From: Laura Gibbons <Laura.Gibbons@arun.gov.uk>
Sent: 16 November 2020 11:28
To: Planning.Responses <Planning.Responses@arun.gov.uk>
Cc: Raymond Cole <Raymond.Cole@arun.gov.uk>
Subject: BE/126/20/DOC and BE/127/20/DOC

Engineers Comments Regarding Condition 5 on BE/126/20/DOC and Condition 3 on BE/127/20/DOC

scheme: Dryan Way, New Barn Lane
North Bersted
client: Bellway Homes Wessex
drawing: Tree Protection Plan
date: 01.08.2019
scale: 1:500@A1
dwg no: BELL22532-01A
drawn: RA checked: TRG

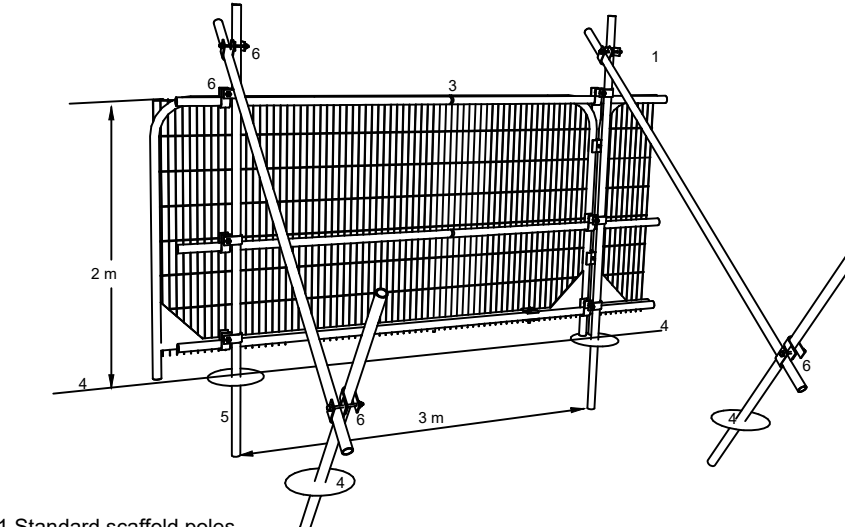
We confirm that we do not recommend discharge of the surface water drainage conditions at this time. Further discussions are required regarding the conflict between trees (both proposed and existing) and the proposed surface water drainage scheme.
